From: Sarah Featherstone [REDACTED]
Sent: 27 September 2019 10:04
To: Anita Gardner <Anita.Gardner@arun.gov.uk>
Cc: Martyn White <Martyn.White@arun.gov.uk>
Subject: Thatch Cottage applications CM/42/19/PL and CM/43/19/L

We have read through Martyn White's (Conservation officer) comments on Thatch Cottage applications CM/42/19/PL and CM/43/19/L which are very useful and encouraging and we would like to confirm and respond as follows:

Thatch Cottage:

Detail of Pocket Sliding Door and Overlay Sliding Shutter

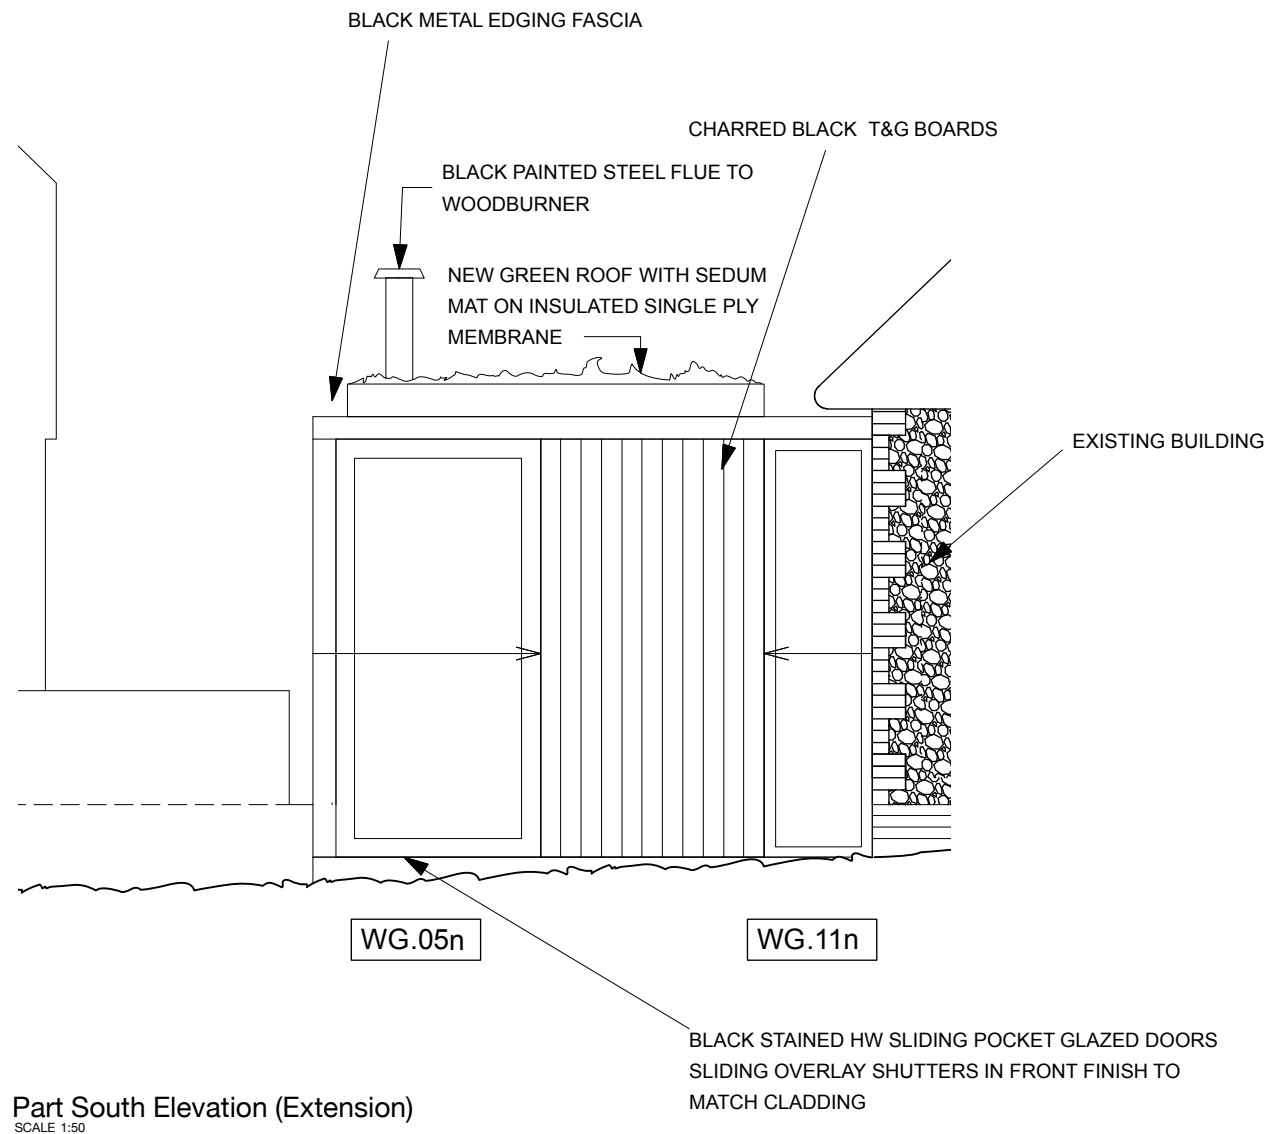
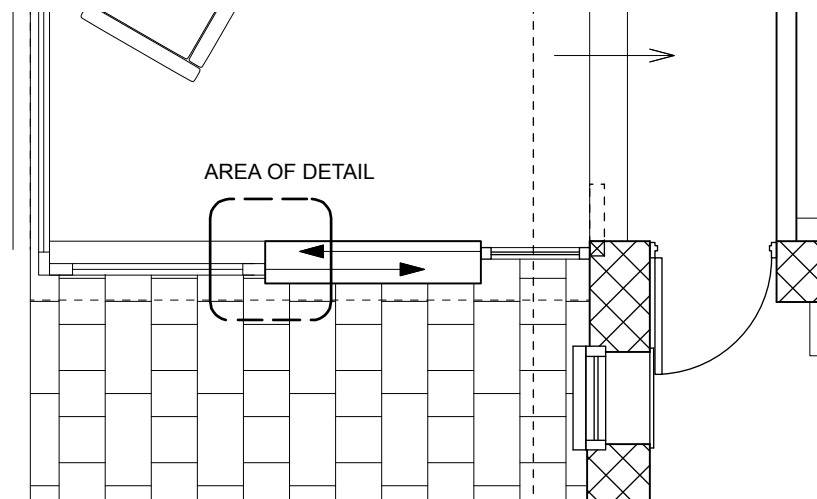
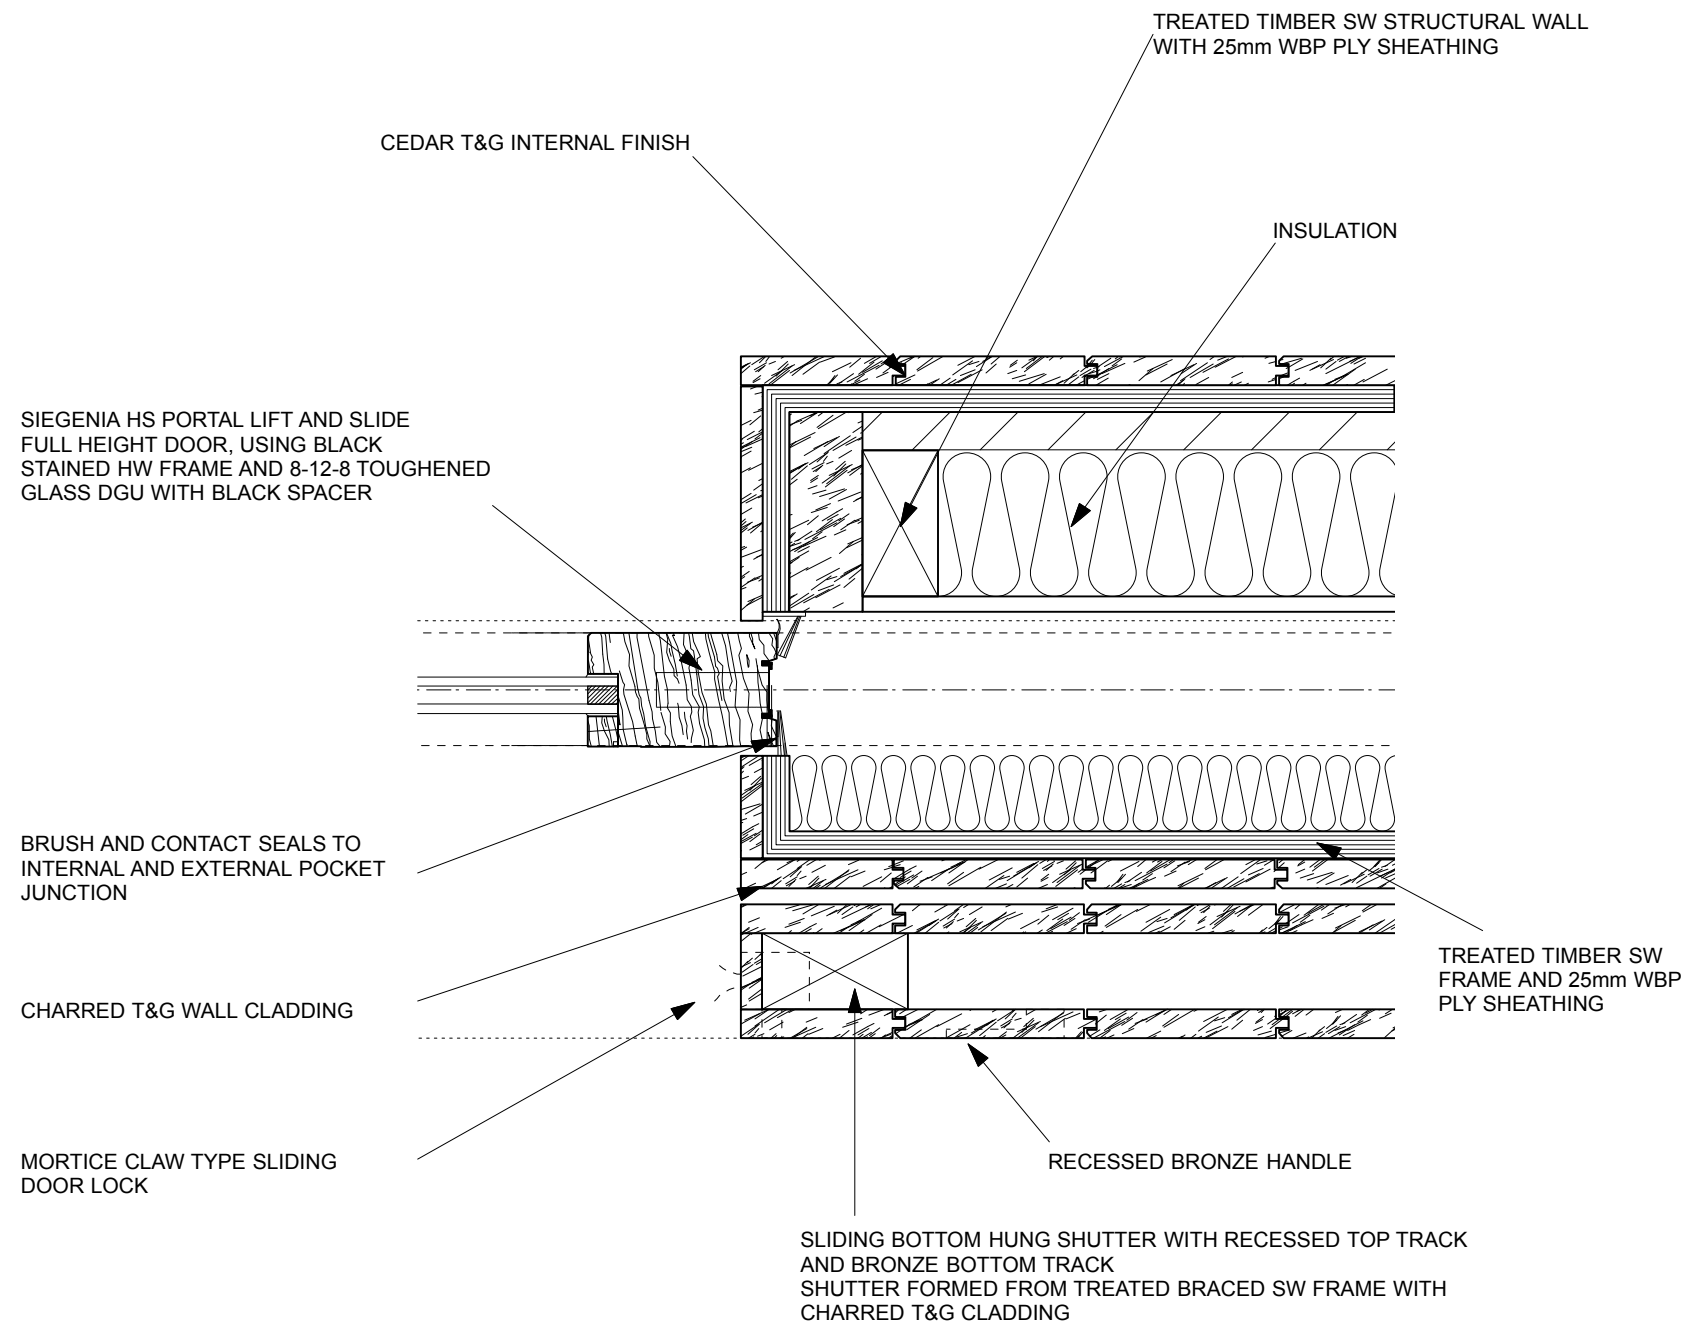
- Shutter details: Window 9 - proposed storm window - we stated "looks better if openings flush with window frame" — MW states "this is matter of detail" . We will provide a detail. Windows 3 & 4 - we understand MW not clear how the shutters operate - they slide in front of external wall. We will provide detail.
- Detail of stone paving specification on external terrace.
- Simple landscape of external garden if required, see note above.
-
- **3. Samples:**
- the side of south terrace ramp is shown faced in brick where it is above grassed ground. The brick will match existing brick quoins. Is it necessary to make up a sample panel for such a small area it is flush to ground at one end and rises above ground to a max height of 300mm at other end?
